CITY OF ALBUQUERQUE

**RE: Perez Collision Center
Grading and Drainage Plan
Engineer's Stamp Date 7-28-16 (File: H14D039)**

Based upon the information provided in your submittal received 8-2-2016, the above-referenced plan is approved for Building Permit and SO-19 Permit with the following conditions:

GRADING AND DRAINAGE PLAN

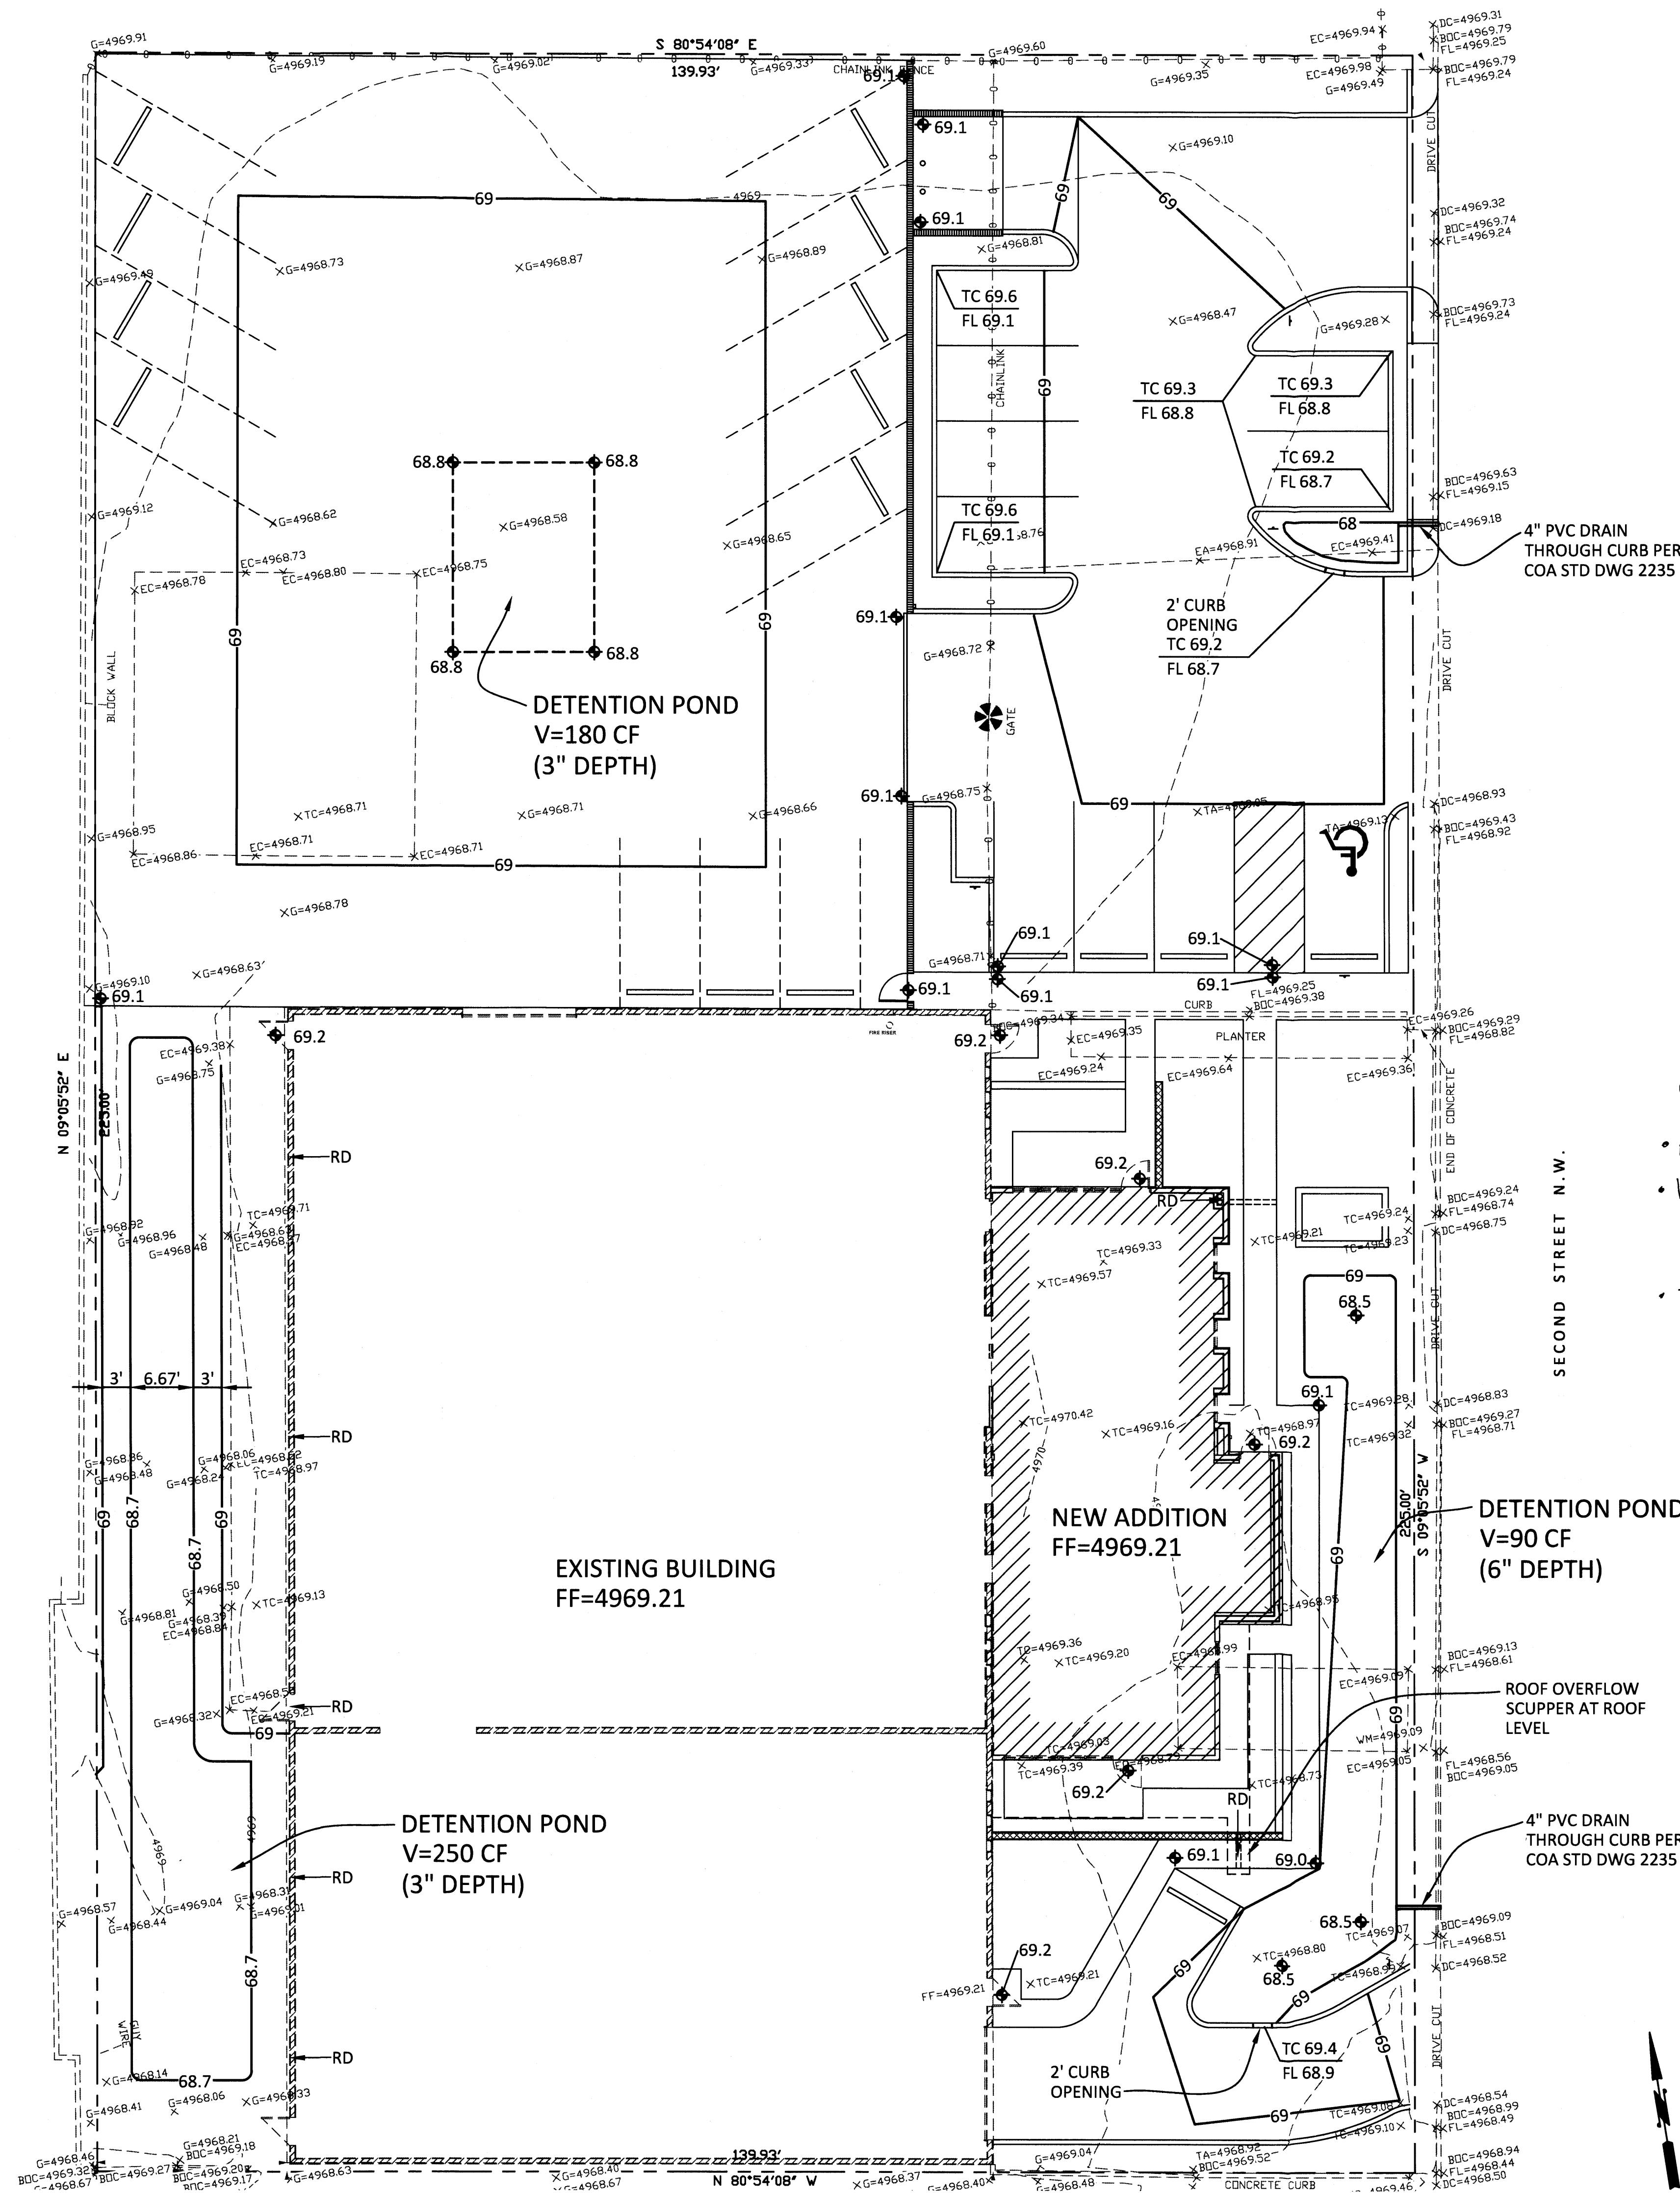
1. The 4" PVC drains across the sidewalk need to be completed through an SO-19 Permit. Attached are the Standard SO-19 Notes, please ensure that they are forwarded to the Contractor prior to Construction. Work in the Right of Way needs to be pre-authorized and accepted by the City. Removals of sidewalk will need to be made at the nearest joint.
2. Provide first flush calculations (required vs provided).
3. Label the areas that will be gravel surfaced and asphalt surfaced.
